From: Dulcie Brookfield [REDACTED]
Sent: 02 July 2020 12:40
To: James Cross <James.Cross@arun.gov.uk>; Anita Gardner <Anita.Gardner@arun.gov.uk>
Subject: Fwd: PlanningObjection: CM/64/19/PL Langford,Horsemere Green Lane BN17 5QZ

OBJECTION CM/64/19/PL Langford Horsemere Green Lane

Plot 8 deliberate misrepresentation by applicant to ADC

Drawing Title:
HOUSE TYPE-F1
FLOOR PLANS

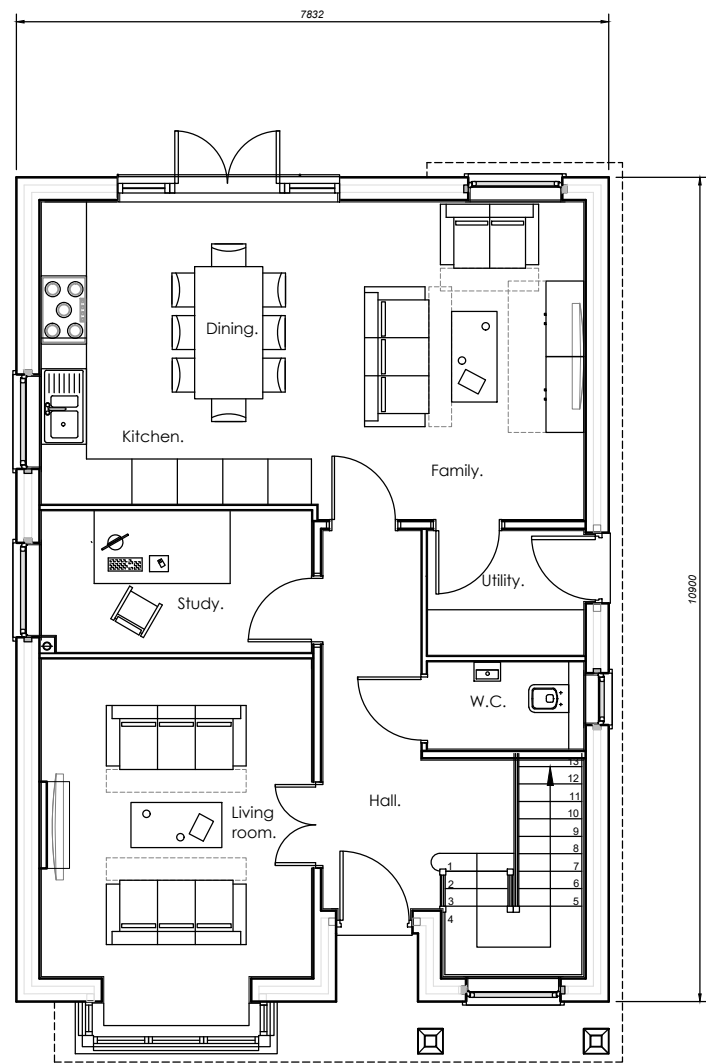
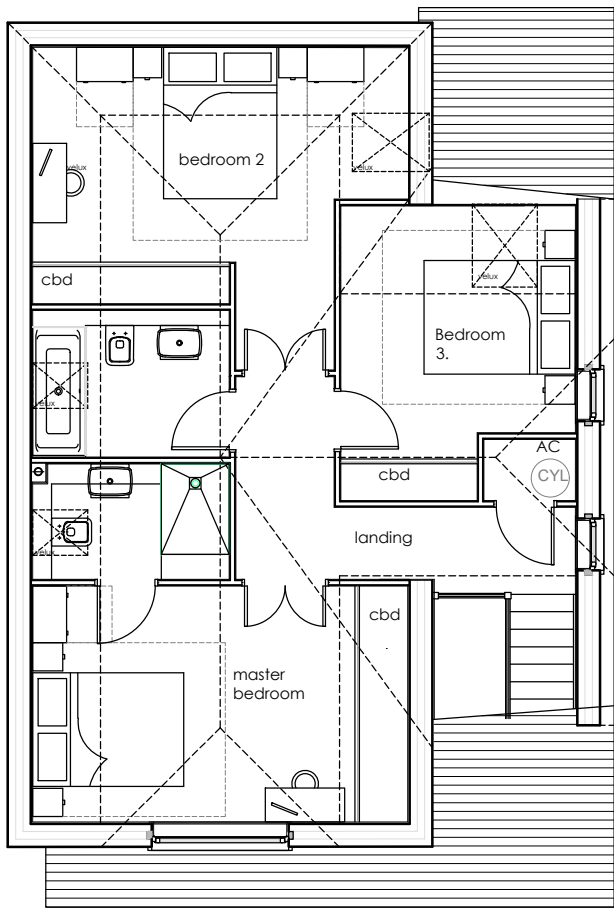
3. The value of my property has been badly affected.
4. PLOT 8 runs the length of my boundary. An application for a 4-bed house type E has been superseded by House type F described as a **3-bed BUNGALOW**. Having looked at the plans this is a **HOUSE** with 2 bedrooms and 2 bathrooms on the first floor, and one bedroom on ground floor. The whole length of the proposed house runs the whole length of my boundary, with permanent structure within feet of my fence. This is very intrusive, and will obliterate light for the majority of the day, completely unacceptable. I speak on behalf of myself and my affected neighbours.

bedrooms and 2 bathrooms on the first floor, and one bedroom on ground floor. The whole length of the proposed house runs the whole length of my boundary, with permanent structure within feet of my fence. This is very intrusive, and will obliterate light for the majority of the day, completely unacceptable. I speak on behalf of myself and my affected neighbours.

Project:
LANGFORD
HORSEMERE GREEN LANE
CLIMPING
Drawing Title:
HOUSE TYPE-F1
ELEVATIONS

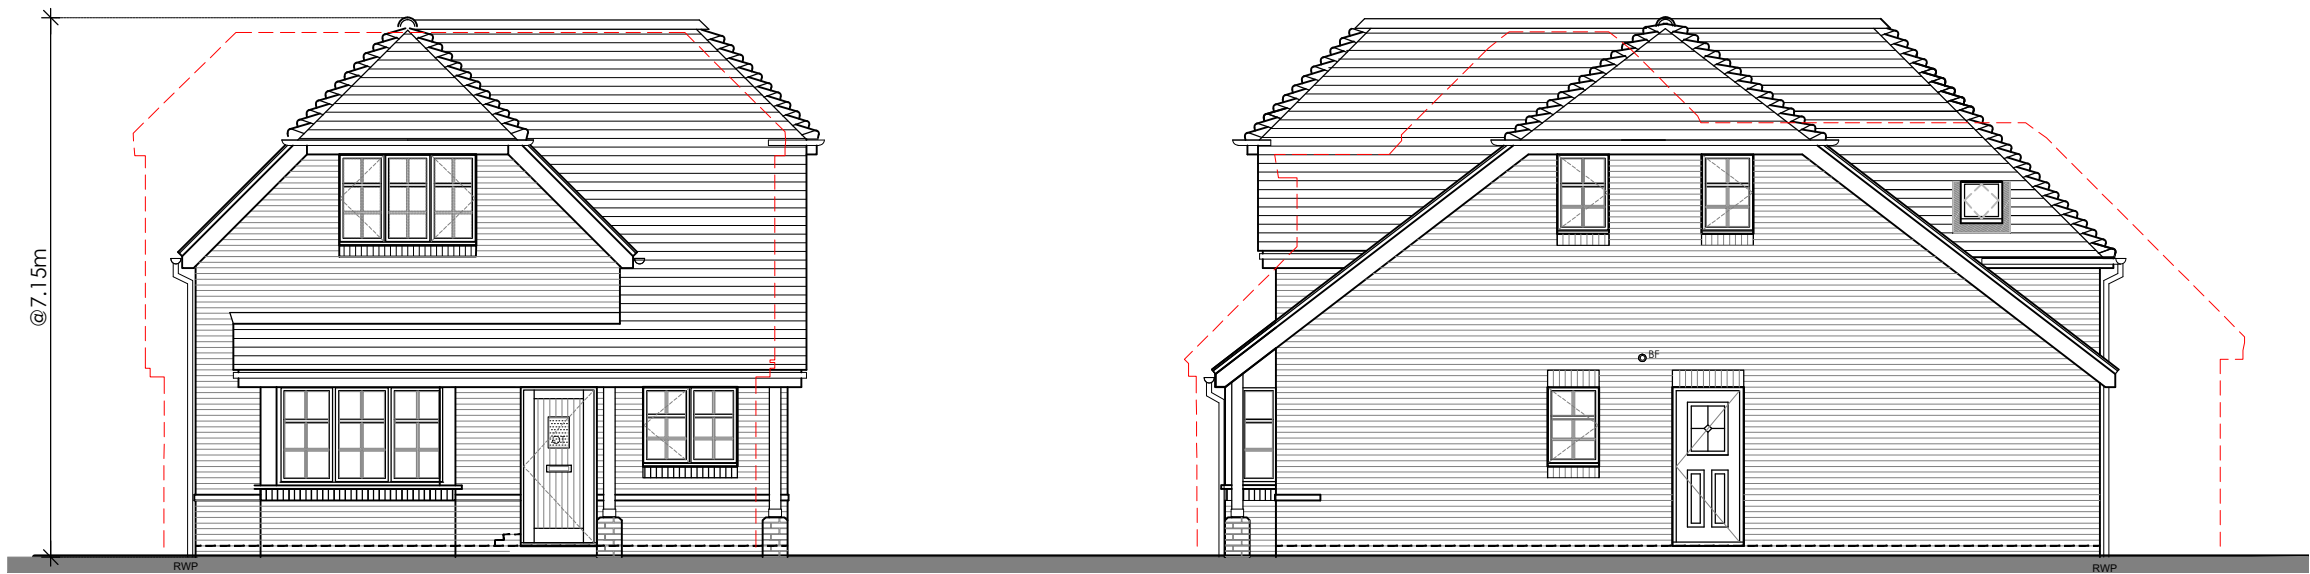
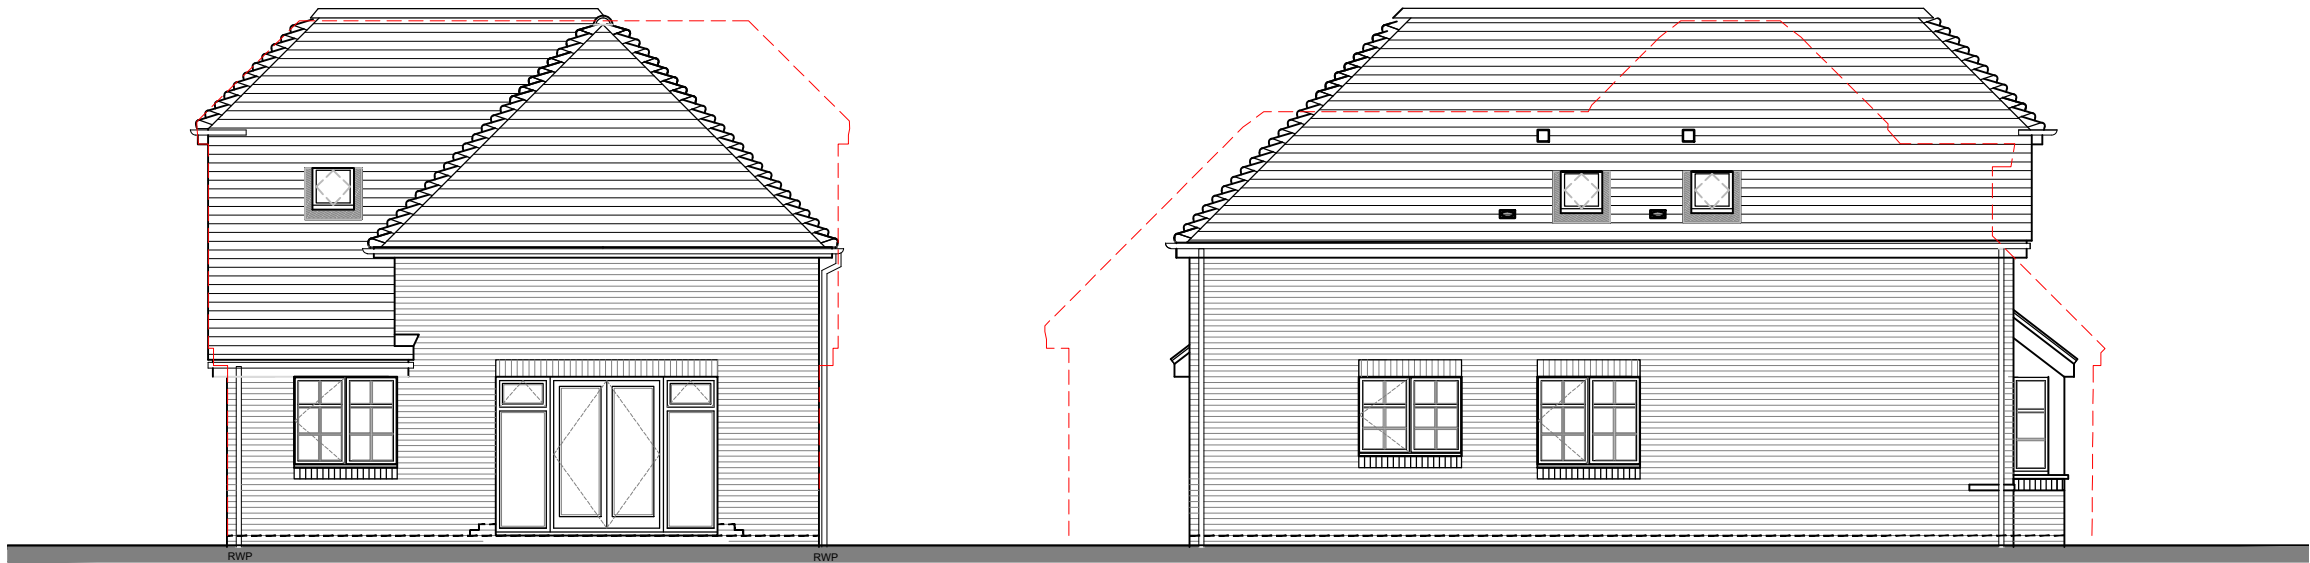
6. If the applicant were to reduce the roof height to single storey, ie, that of a bungalow, as proposed, and lower the ground level, this would fall in line with their proposal of '**2 x 3-bed bungalows**' made to Arun District Council.
